Planning Department  
Ribble Valley Borough Council  
Council Offices  
Church Walk  
Clitheroe  
Lancashire  
BB7 2RA

**Letter of formal objection to application no. 3/2020/0424 for the demolition of an existing dwelling and erection of replacement two-storey dwelling at Parsons Croft, Slaidburn Road, Waddington, Lancashire, BB7 3JQ**

street elevation

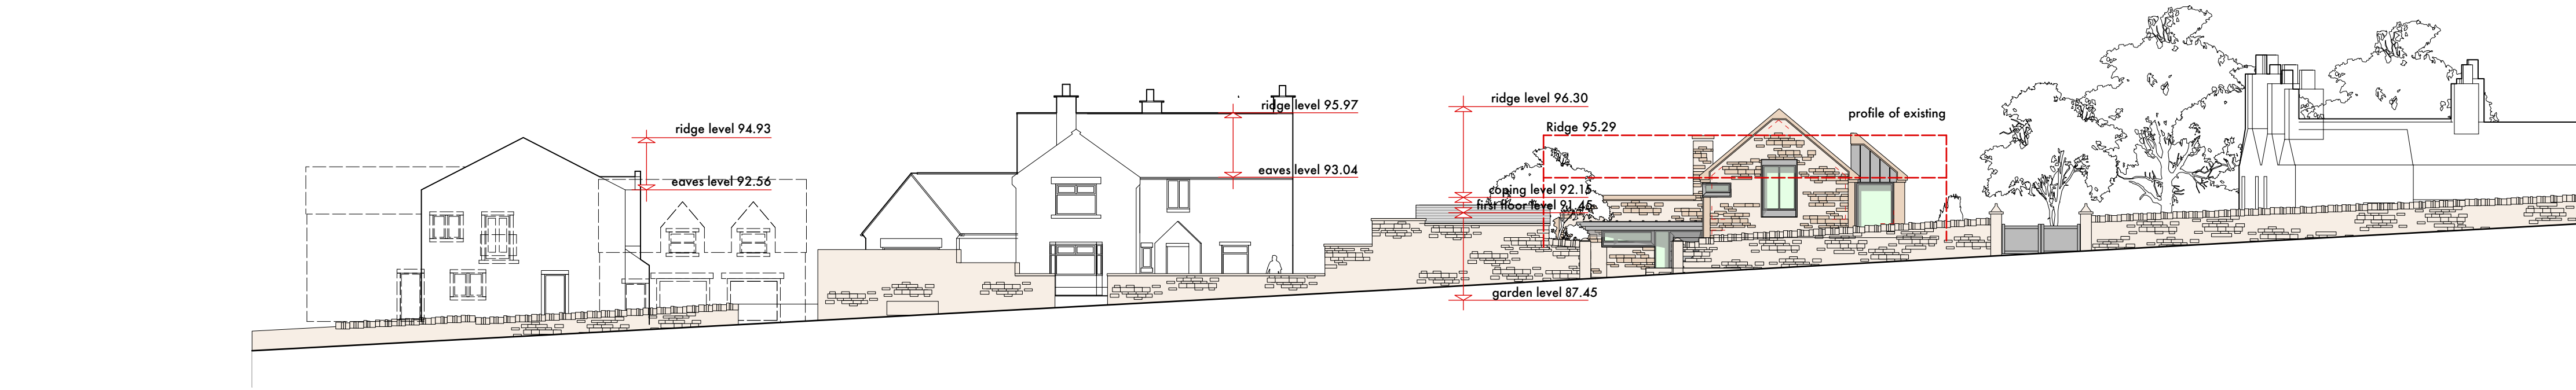
11. Although the length of the proposed dwelling has been reduced, largely achieved through the omission of the adjoining garage block, the dwelling remains substantially larger than the existing dwelling. The design statement states that "The proposed dwelling is similar in width and height to the existing.". Whilst the width may be similar and has been maintained since the previously refused application, the height is not and is still proposed at approximately 1m higher than the existing dwelling and is slightly higher than the ridge level of Glebe House, which maintains the over-bearing nature and dominance of the proposed dwelling within the streetscape. The submitted Design Statement suggest that the footprint of the house appears to be twice of that of the existing dwelling, however it does not appear to be considerably smaller than the surrounding dwellings as falsely asserted within the submitted Design Statement. This is apparent when viewing the proposed site plan as the proposed dwelling appears to be considerably larger than the neighbouring vicarage. The depth of the house is also considerably deeper than the existing dwelling with an overall revised depth of 20.45m which is only a minor reduction from the 23m as was previously proposed. The proposed building to plot ratio remains inappropriate given that the building still occupies the majority of the site due to its large size and plan form with only a small reduction in size on what was originally proposed. This will still result in a dominant and overbearing elevation facing west towards Glebe House which has only been moved away from the boundary wall by a mere 1m and would still cause harm to the setting of the grade II listed building.

2 south elevation

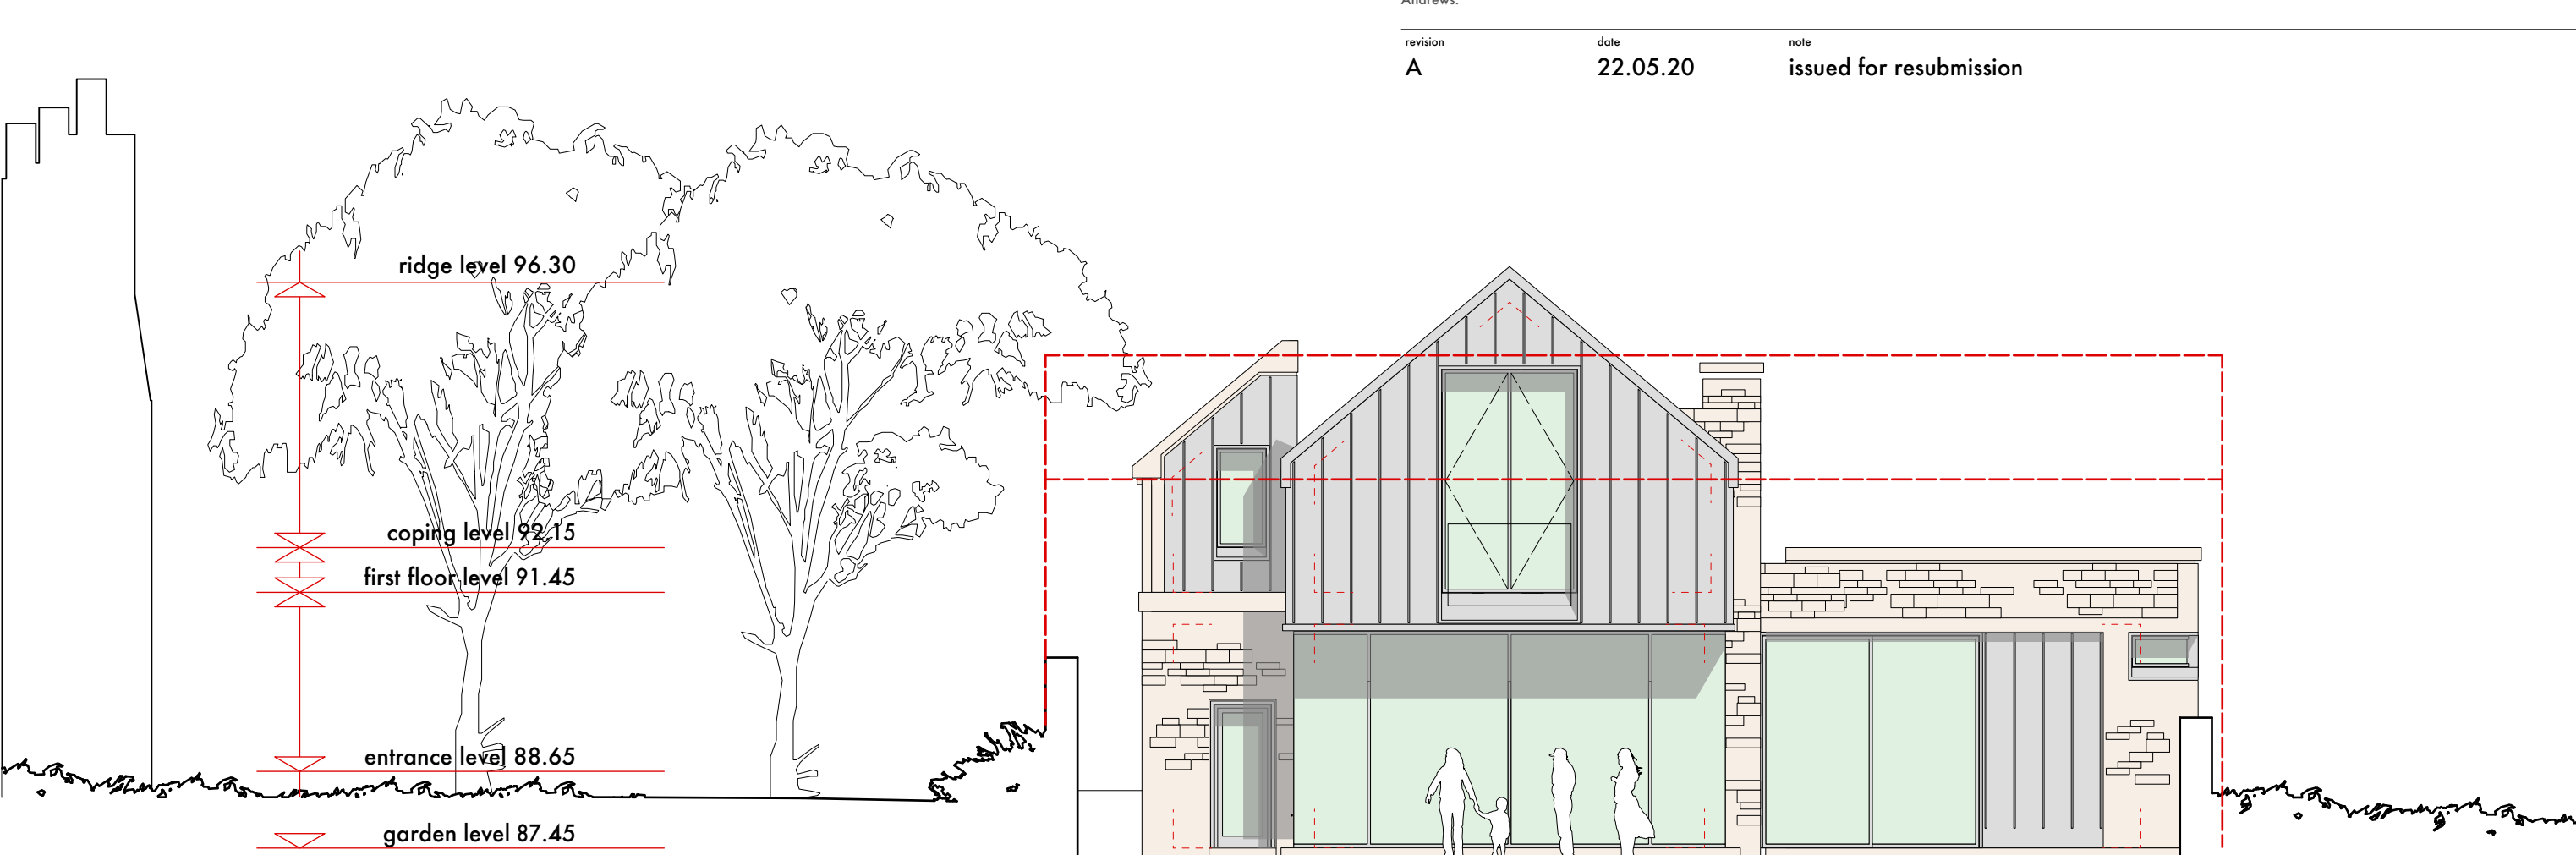
4. The material choices remain mostly appropriate and have not been altered from the previously refused application. This includes the proposal for zinc cladding to the south elevation, most notably the large gable end to this elevation as well as to the north and south elevation of the proposed circulation wing. As stated previously, this will be very visible from within the site of Glebe House and also in views across the Conservation Area from Beechthorpe Avenue and Carter Fold. The zinc cladding to the north elevation of the proposed circulation wing will be visible from Slaidburn Road. The submitted design statement attempts to justify the use of zinc cladding through the use of such cladding within a development at the Three Millstones Inn in West Bradford. In our opinion, this example holds no weight as justification for this material choice as the context of the application site is vastly different to that of the example of the Three Millstones Inn which is some 1.5km away and outside of the village of Waddington and a Conservation Area. As a result, a local precedent, within the Waddington Conservation Area, has not been provided.
